1 No three bedroom detached house

Land to the rear of 20 and 22 Broadmark Lane Rustington

Thank you for your internet representation made on 3rd September 2013 which has been recorded as '**an objection**' with the comments as follows:

PROPOSED STREET (SOUTH) ELEVATION (1:200)

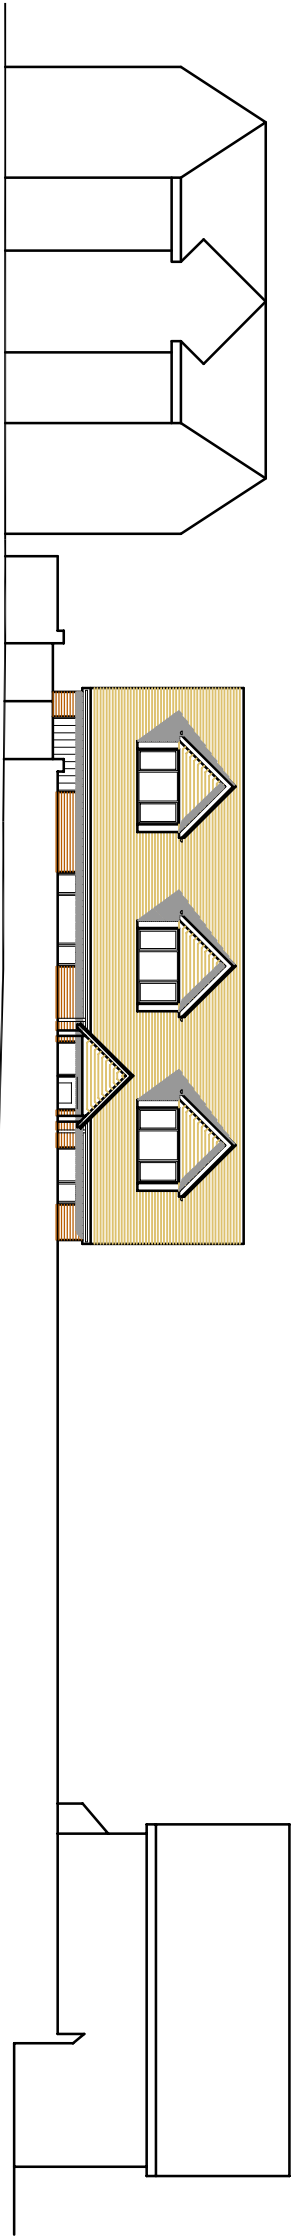
The proposed build will definitely effect the existing outlook and seriously overshadow No. 4 Broadmark Way.

This proposed infill site will significantly overbear and shadow No. 20 Broadmark Lane and No. 4 Broadmark Way and will cause severe shadowing to No. 22 Broadmark Lane.

DRAWING TITLE
PROPOSED FLOOR PLANS & ROOF PLAN

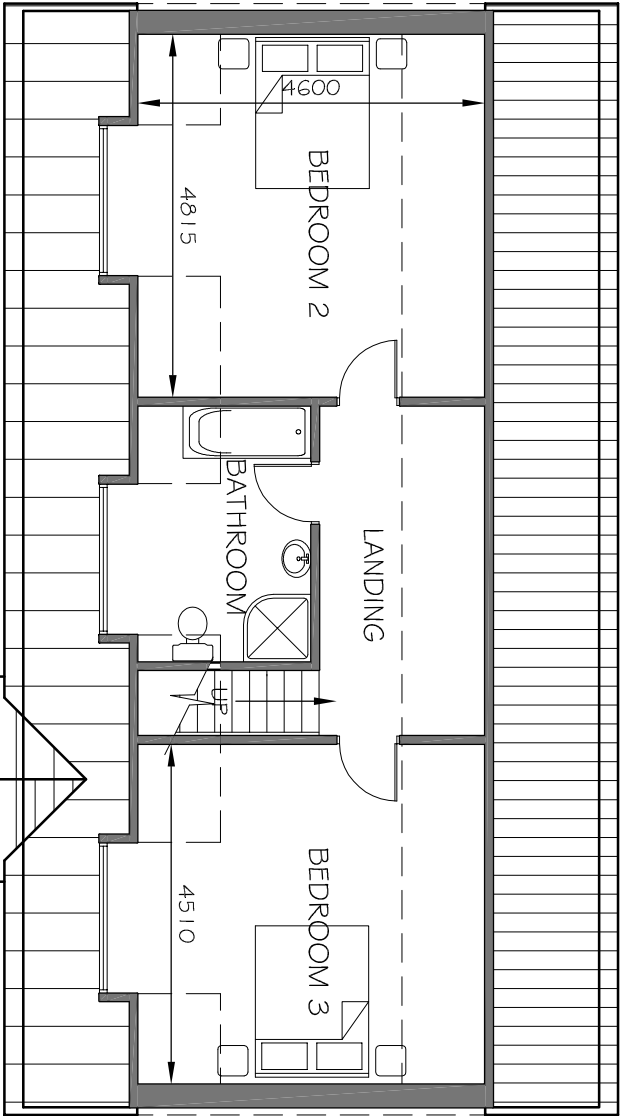
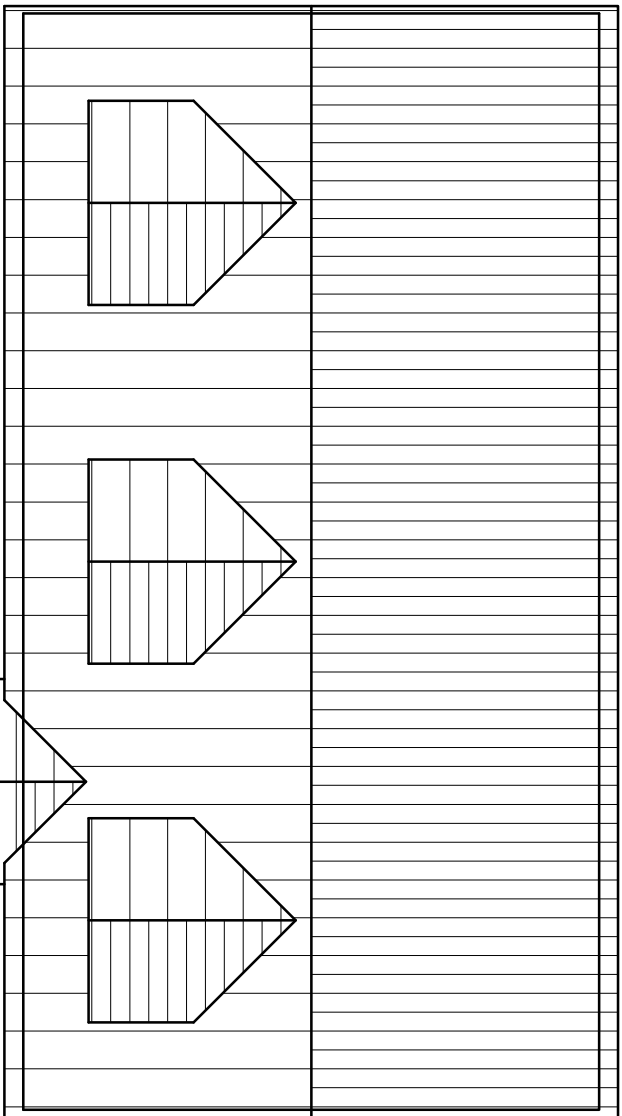
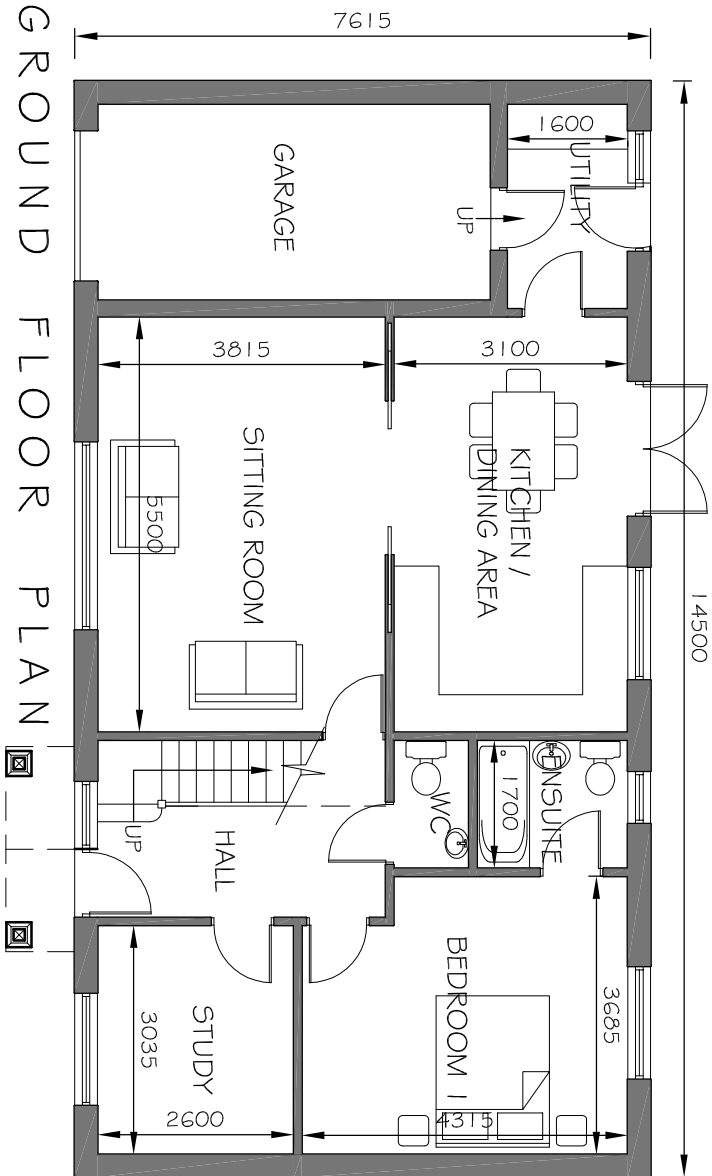
At a later date there will be nothing to stop the owner of this proposed property putting Velux windows in the roof, this will be in breach of current planning.

DRAWING TITLE
SITE LOCATION AND LAYOUT PLANS

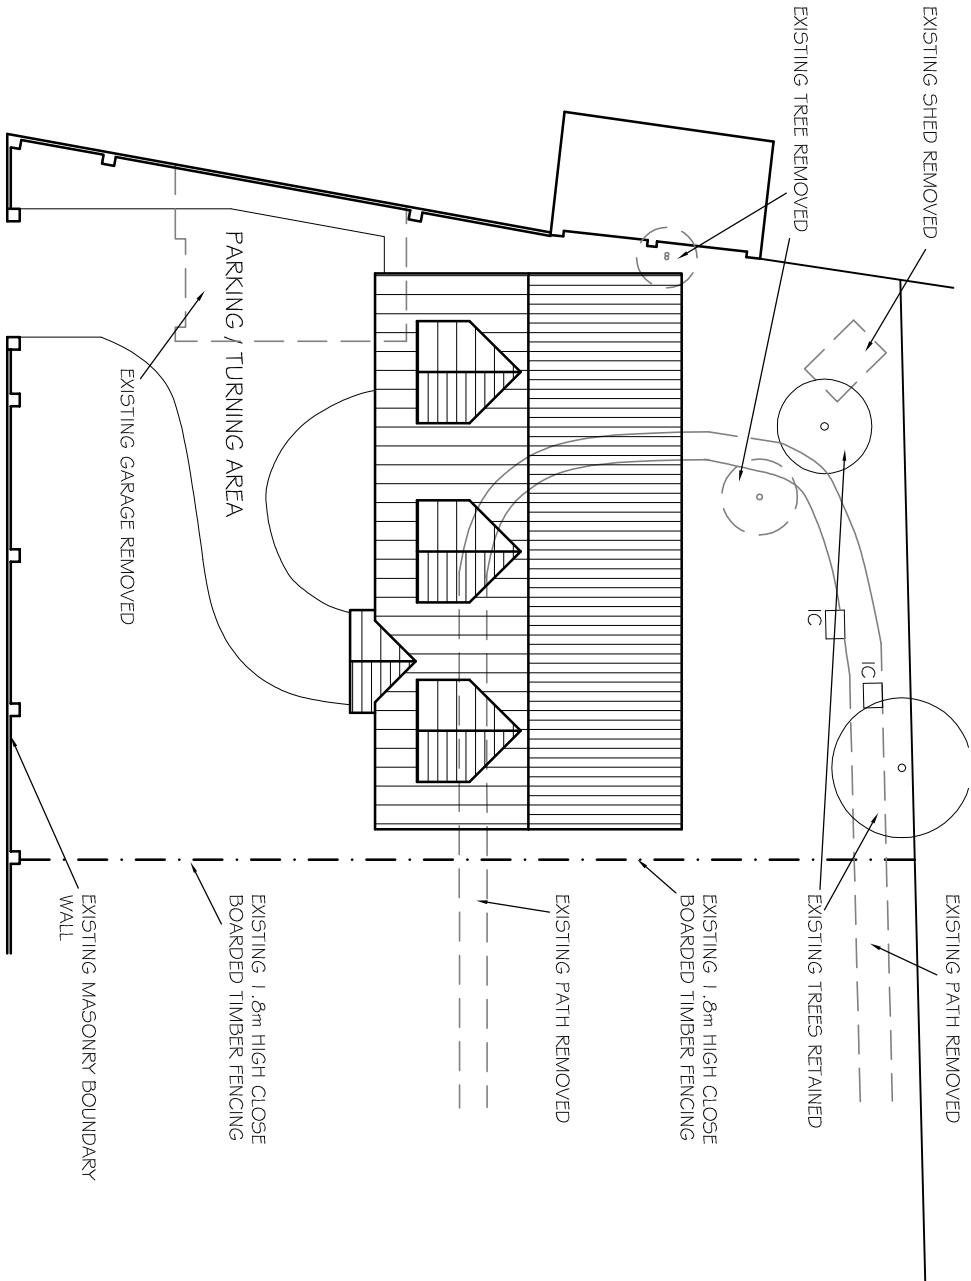
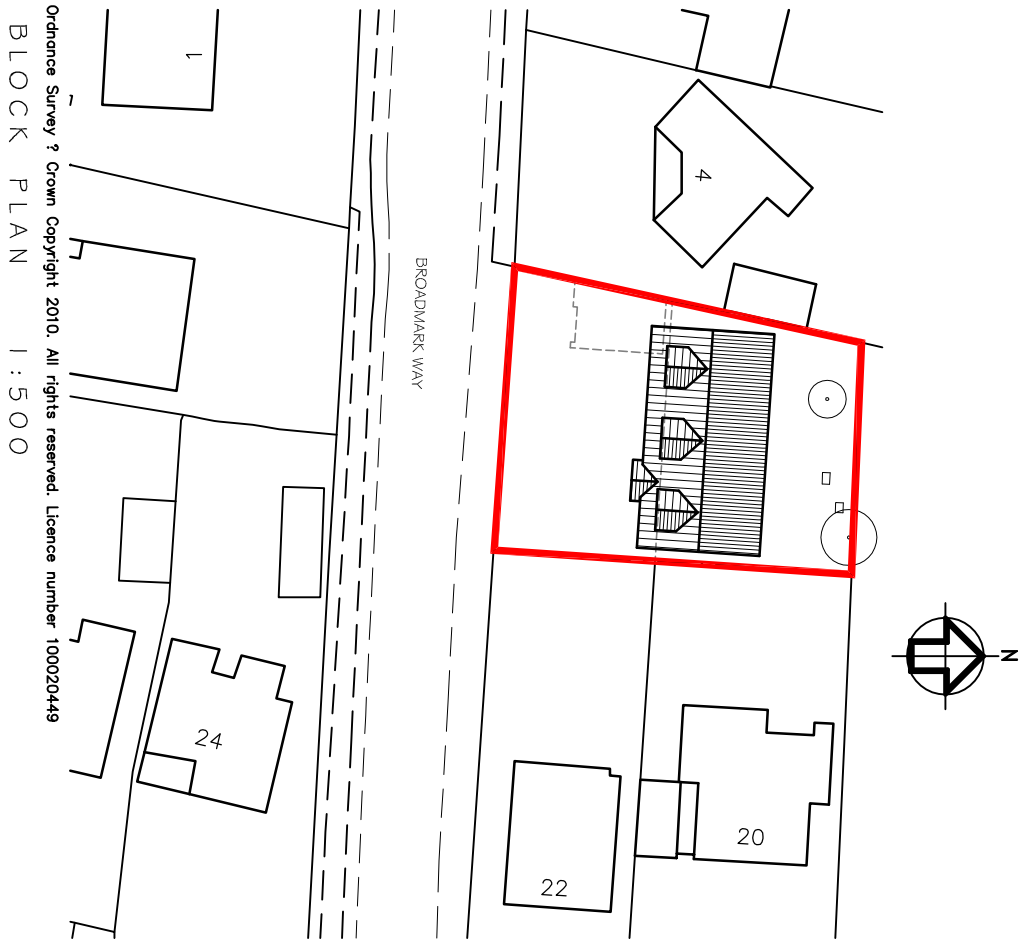
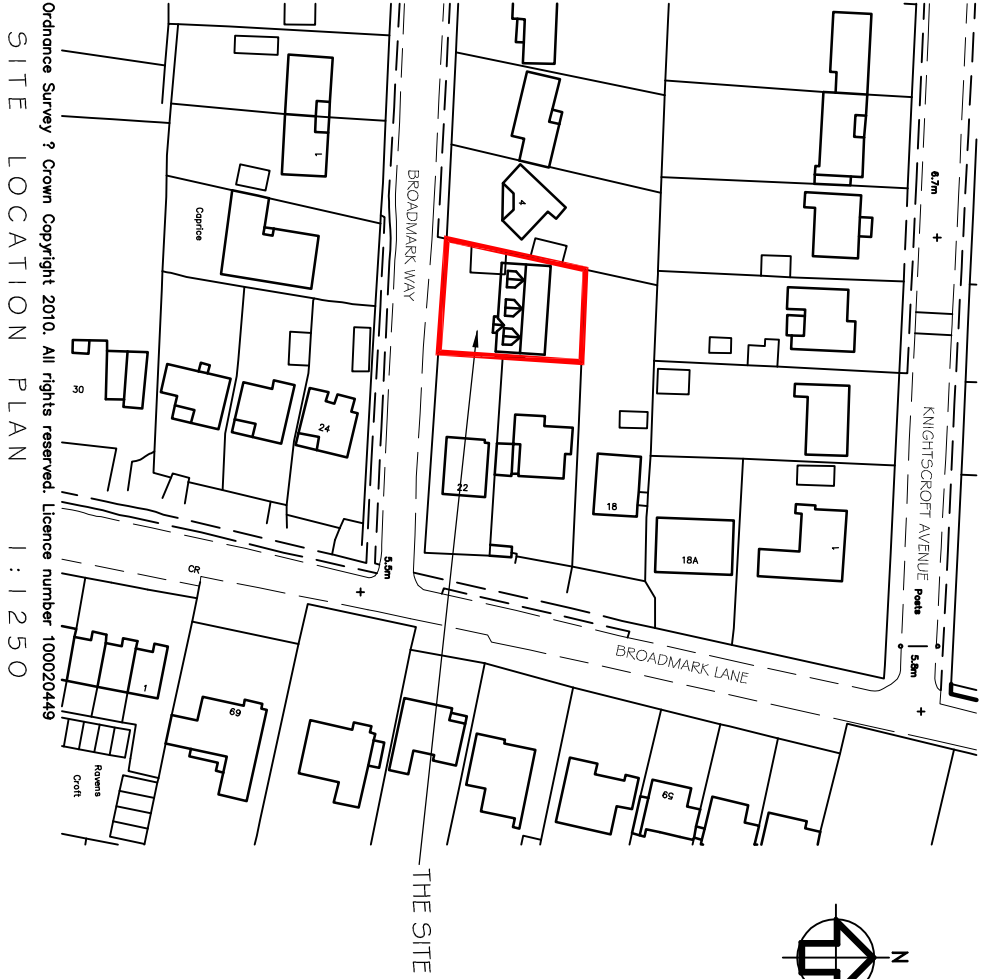
The proposed infill property will be too close to the boundary fences of No.s 22 and 20 Broadmark Lane and 4 Broadmark Way.

Any more than one vehicle parked on the front standing area of the proposed property will be too close to all the neighbouring properties boundaries and Broadmark Way has a very strict no parking policy on the road and family houses generally have several vehicles needing parking space.
